WEST SUSSEX COUNTY COUNCIL CONSULTATION

TO:	Arun District Council FAO: Simon Davis
FROM:	WSCC - Highways Authority
DATE:	12 May 2020
LOCATION:	Land To South Of Barnside Hook Lane Aldingbourne PO20 3TE
SUBJECT:	AL/28/20/DOC Approval of details reserved by condition imposed under ref APP/C3810/W/16/3155330 (AL/8/16/OUT) relating to Condition Nos 11 - visibility splay, 12 - fire hydrant, 13 - foul drainage, 14 - surface water drainage and 18 - external lighting.
DATE OF SITE VISIT:	n/a
RECOMMENDATION:	Advice
S106 CONTRIBUTION TOTAL:	n/a

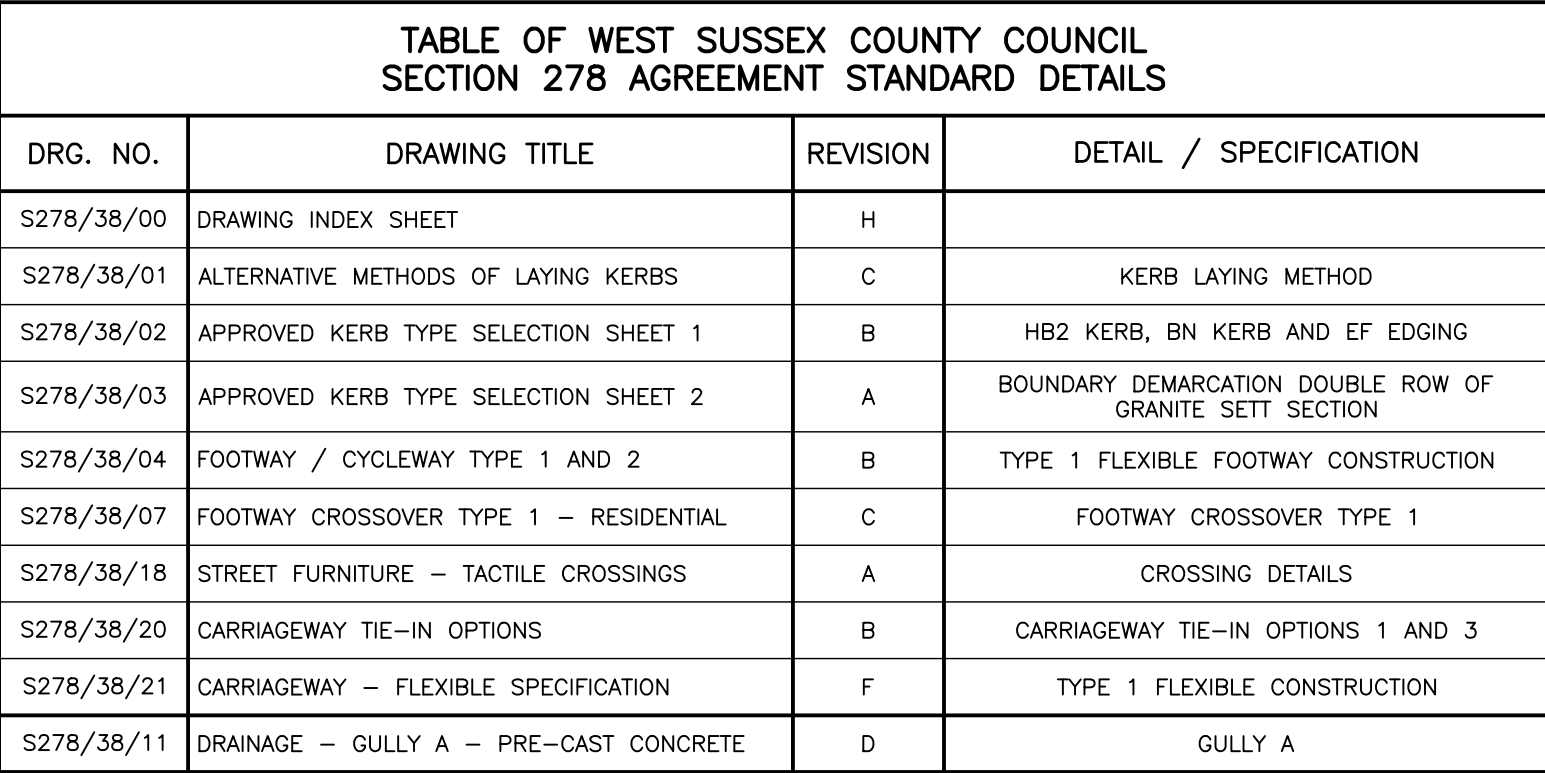
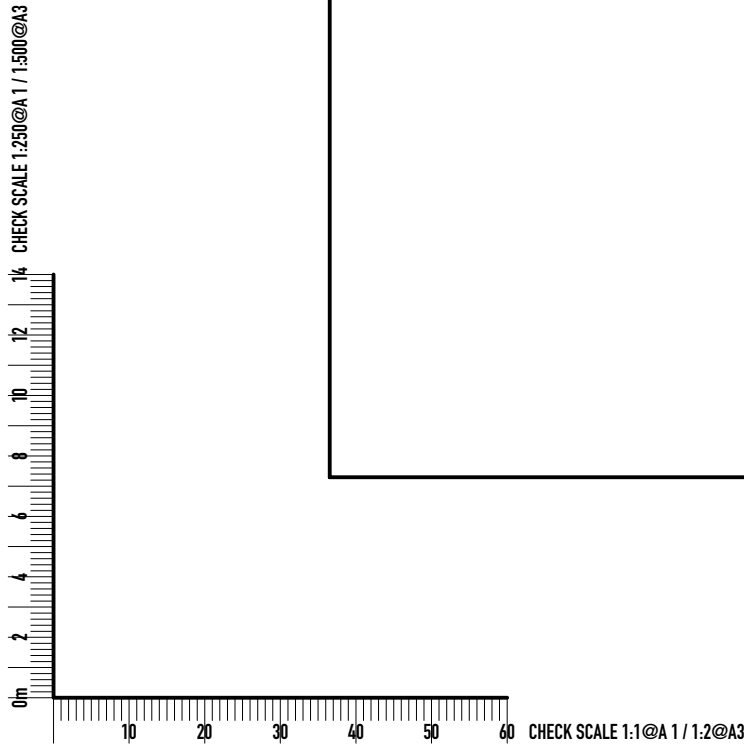
For the purposes of this application Condition 11 is most relevant to highway matters. This relates to visibility splays at the site entrance and has been subject to a Section 278 Agreement with the LHA. Having assessed the drawing AAL-156-520 P4 the LHA would be satisfied that this condition can be discharged.
